BCA ASSESSMENT REPORT

**Metcash Distribution Centre
Bungarribee Industrial Estate Huntingwood NSW**

PROJECT MUSTANG

15 November 2012

Figure 8-1: Egress provisions

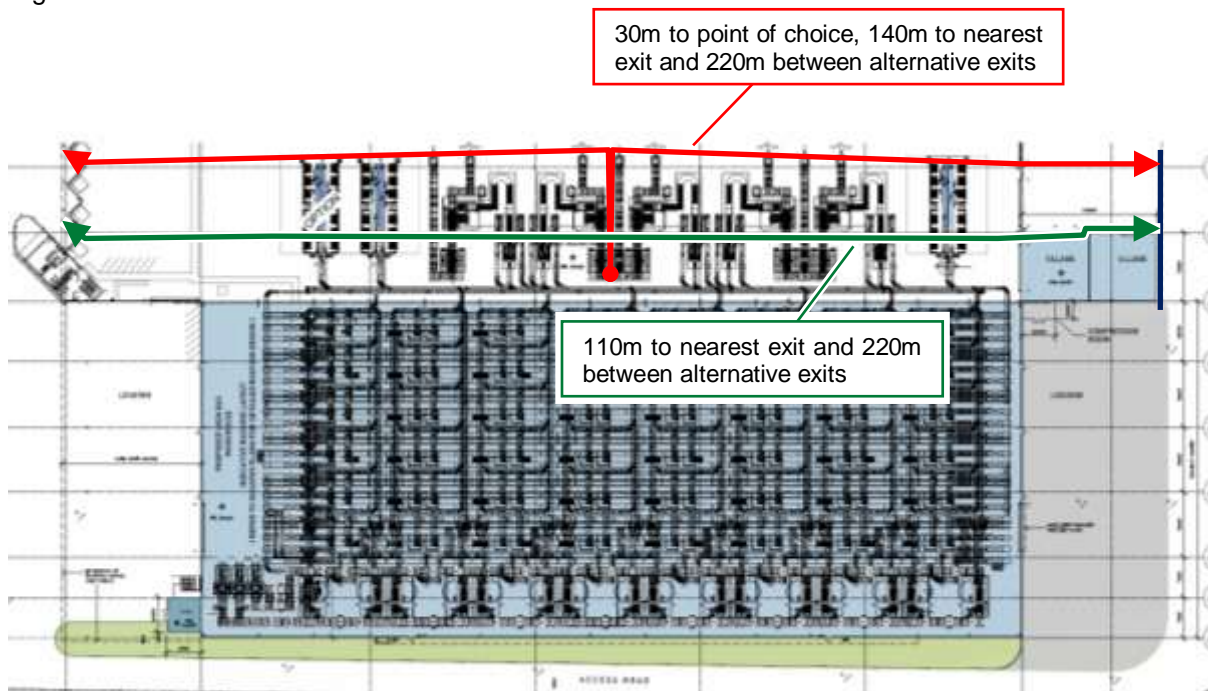
Having regards to the size of the new addition, the exit travel distances will not comply with the 40 metre requirement to an exit. In this regard we note that egress distances from the staging area directly to the north of the caged automated enclosure is approximately 140m to an exit from the worst affected central areas of the warehouse and there is also a potential point of choice to alternative exits non-compliance of up to 30m. Fully detailed design of this staging area is required to determine the exact egress distances from this area at the CC stage and prior to the development of the Fire Engineering Brief.

Similarly to our assessment under D1.4, the staging area to the north of the enclosed automated racking system is non-compliant and has distance between alternative exits of up to 220m, when measured clear of awnings on each side of the building.

Figure 8-3: Non-compliant vehicular perimeter access

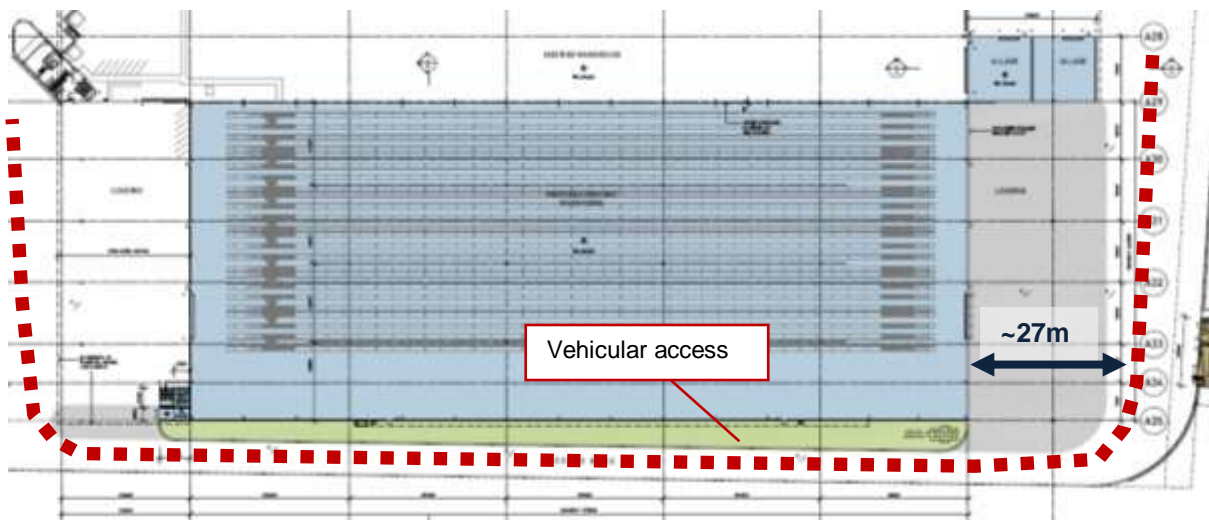
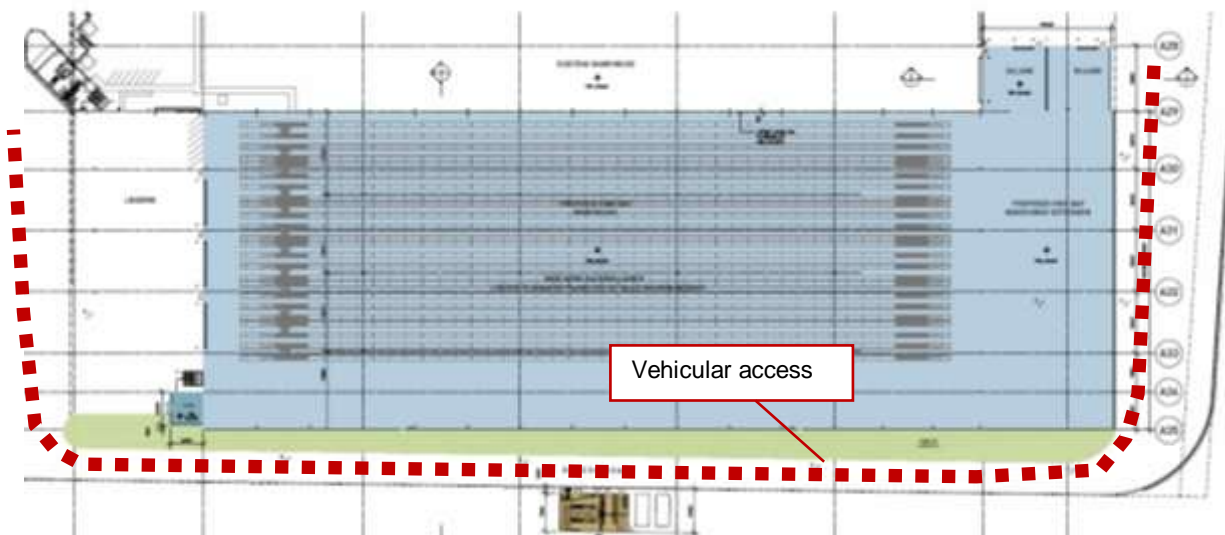
Note 1: The perimeter access road in the South East corner of the new addition appears to be greater than 18 metres from the building. As such, either design changes or modifications to the Base Building Fire Engineered Alternative Solution addressing the Performance Requirement CP9 is required in consultation with Fire & Rescue NSW.
